ExQ3	Question to	Question	NCC comments
Q3.0.5	The Applicant, NCC, NSDC	<p><b>Habitat Severance</b> During ISH 4 [EV10-002] it was confirmed that NSDC no longer had any concerns relating to habitat severance. NCC commented that it is still in discussion on this point and would address this through the SoCG.</p> <p>Can all parties please ensure the matter of habitat severance is included in their SoCG and confirm if they are content that this issue has been resolved. If NCC continues to have concerns, please detail these and how might they be reasonably addressed.</p>	NCC notes the applicant's response to comments on Habitat severance within REP3-037 and at EV10-002 and has no further concerns /comments. This has now been closed out on the SoCG.
Q5.0.16	Applicant, NCC	<p><b>Land Rights Tracker URN 038</b> It is stated a further meeting is being arranged for February to discuss acquisition by agreement, did this take place? Please ensure information provided as to the nature of any outstanding issues and the positions of the parties, as in the event agreement is not reached by the conclusion of the examination, the Panel will need to adjudicate and provide a recommendation to the SoS<

# Additional Wireframe from Great North Road looking north towards Cattle Market Junction

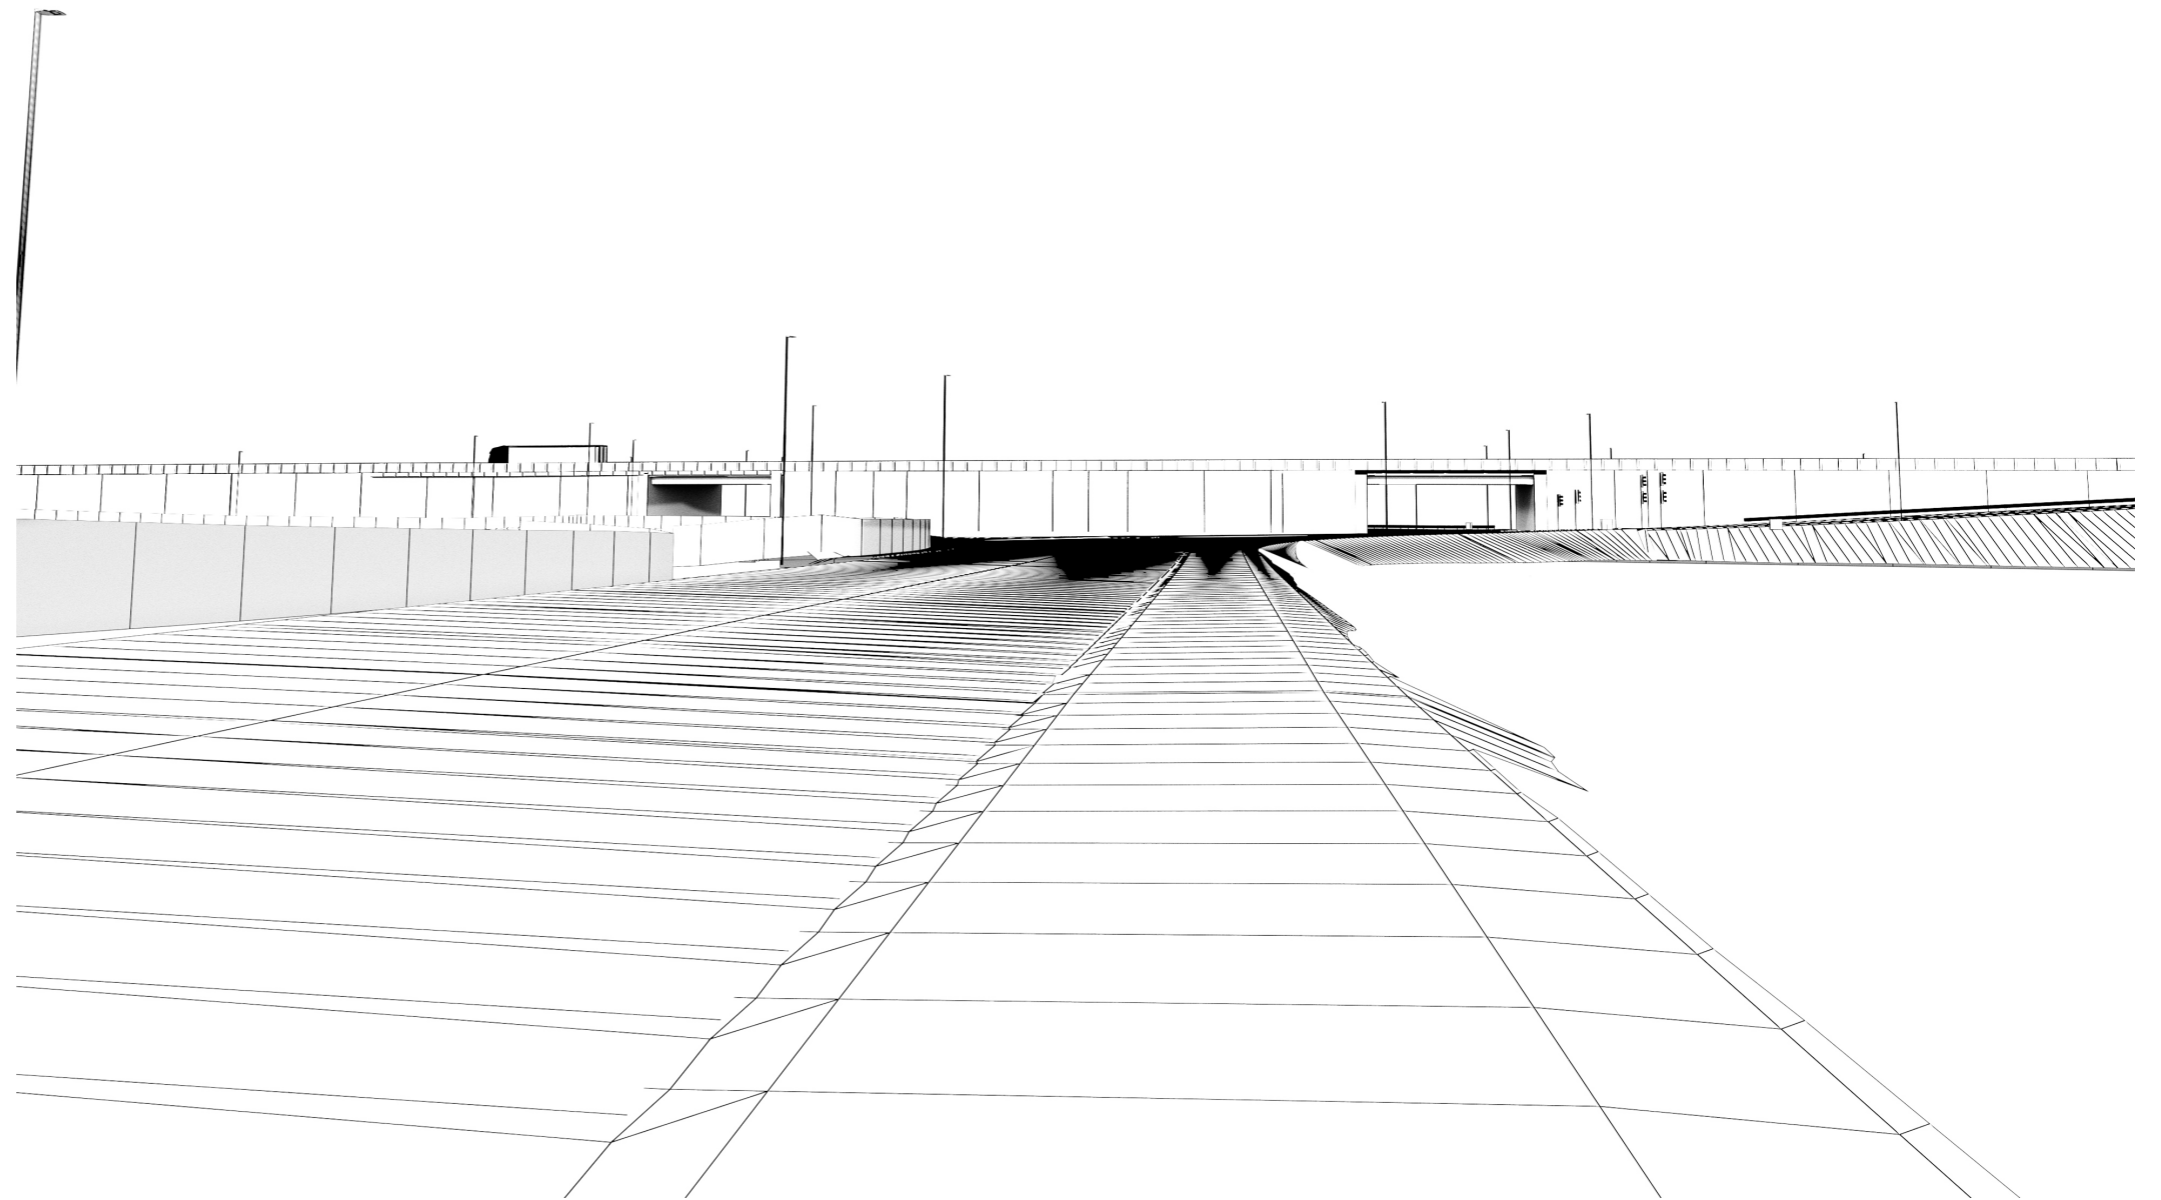
Q10.0.1	The Applicant	<p><b>Finishing Materials of Cattle Market Grade Separated Junction</b></p> <p>In [REP4-040] 3.6, page 19 the applicant confirms that the material finish of the Cattle Market grade separated junction will include a banding of red brick material and that this, coupled with landscaping, will</p>	<p>There is a need to identify the type and extent of red material being proposed, REP4-040 3.6 refers to 'blocks' rather than 'bricks', but clearly a red brick would be the most appropriate detail to tie in with the material palette of the Smeaton's Arches heritage. The use of coloured 'blocks' would offer very limited aesthetic mitigation (especially if this was simply a coloured concrete block).</p>

assist in reducing the potential adverse impacts on views towards Newark travelling south along the Great North Road. How is this secured through the dDCO and are there any drawings and/ or documents that require to be certified to be updated to reflect this? Does this need to be captured in the Requirements and if so, should NSDC be a consultee?	The precise details of the materials need to be submitted to NSDC and NCC and examined further to ensure that they are achieving the stated aims.
Q13.0.1	The Applicant, NCC	<b>LTN Standards</b> a) Why is there a difference in opinion on LTN standards between the Applicant and NCC? b) Can anything be done to address NCC's concerns expressed in response to ExQ2 13.0.5 [REP5-069].	NCC's understanding is that the applicant considers the design acceptable based on the number of users. There is a table in LTN 1/20 that offers guidance on the width of potential shared use facilities, based on the number of users. However, it is the Council's understanding that regardless of the pedestrian/cycle volumes, the over-riding design principle is that shared use footways should be introduced only as a last resort. Para 6.5.4 states: "In urban areas, the conversion of a footway to shared use should be regarded as a last resort." In NCC's experience ATE has not supported designs that incorporate shared use at locations where the pedestrian/cycle volumes are well below the threshold set out in the document.
